Hideaway Resort, AL-20-13

Please accept the following comments from El Paso County Public Health (EPCPD) for an amendment to the 2009 approved special use request and the special use requests contained in the referenced project above:

SITE PLAN P2 OF 2

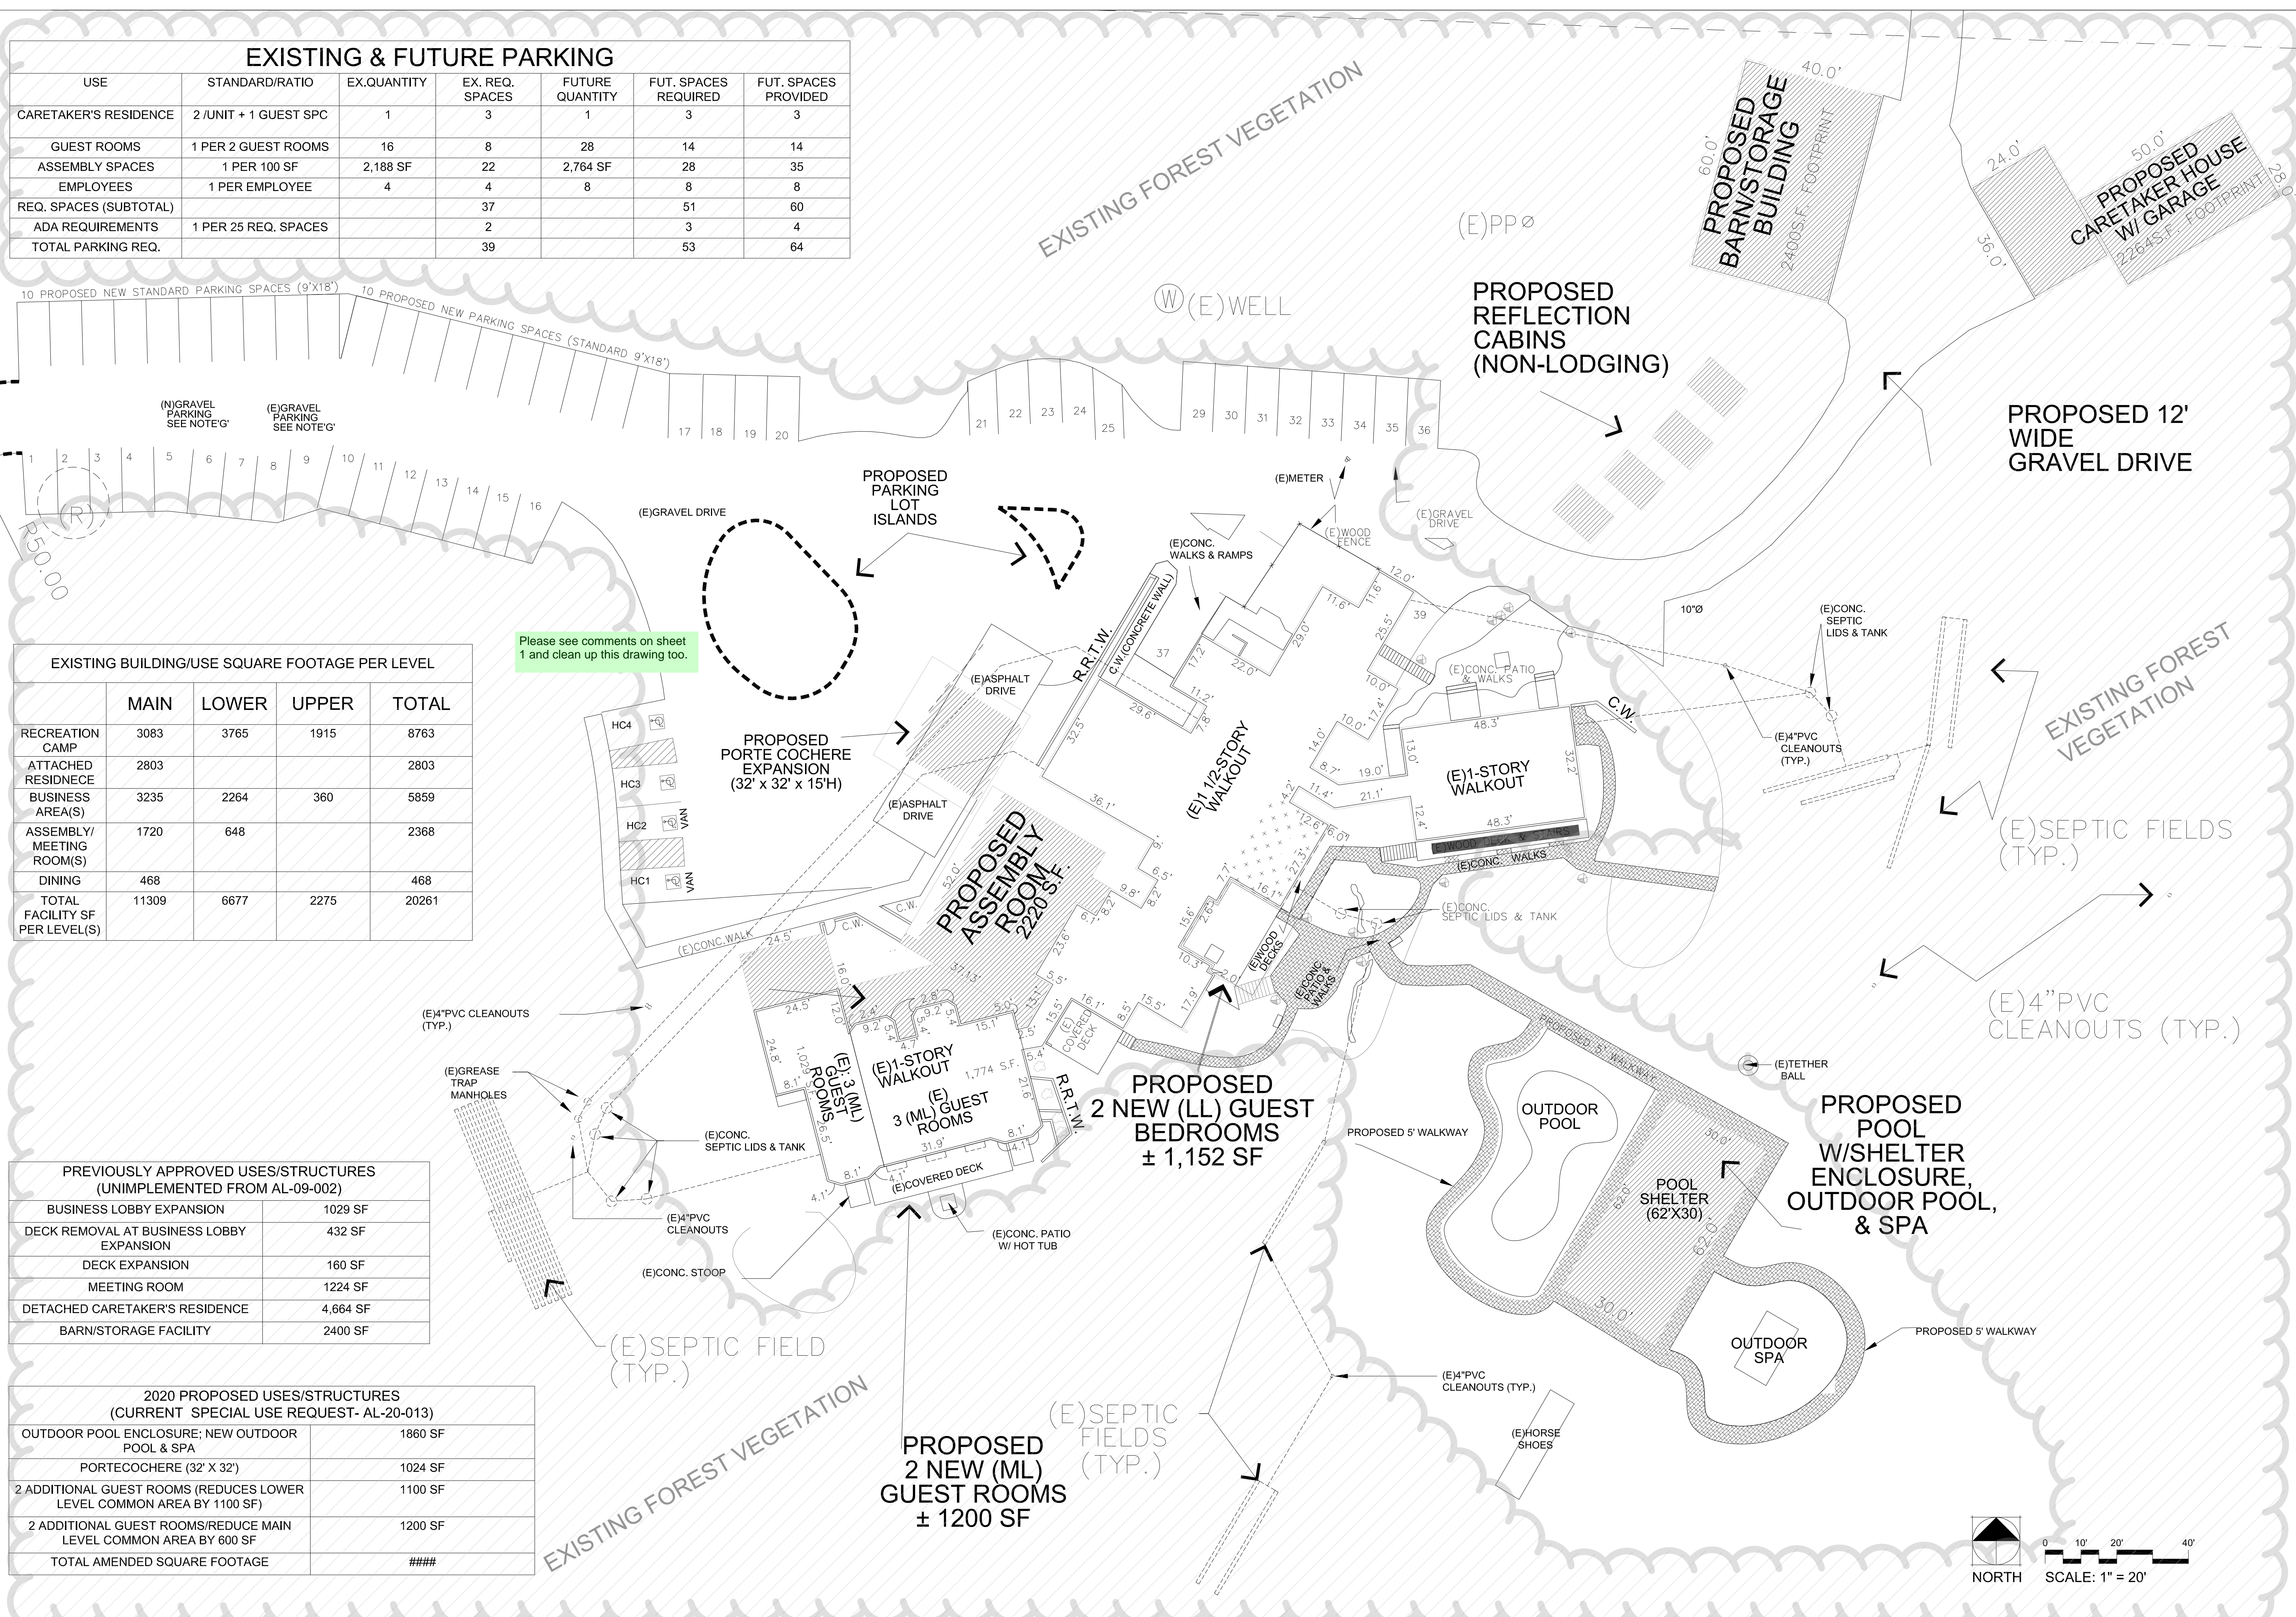
- Water for the site is provided by an individual well and is classified as a Transient, Non-Community Ground Water System by the Colorado Department of Public Health and Environment (CDPHE) and has been assigned PWSID #CO0221338. The CDPHE, Water Quality Control Division, must be notified of the proposed change in the population served so they can update their records.
- Phase V: Suggest having the larger pool enclosure reviewed by our Department just to assure the pool/spa deck clearances are satisfied.

The plans for the proposed inground pool and spa must be submitted to El Paso County Public Health for review and approval prior to construction.

- Phase VIII: A Colorado Registered Professional Engineer must submit an evaluation of the affects the guest room additions, the increase in the maximum number of guests from 100 to 115, the increase in the number of overnight guests from 50 to 56, and the proposed addition of wedding events will have on the existing onsite wastewater treatment systems (OWTS's). Any increase in any soil treatment area (STA) size will require a Major Repair Permit. This evaluation must include the new calculated setbacks of the affected STA's to the existing well.
- With the proposed addition of wedding events, are there any changes to food preparation onsite?
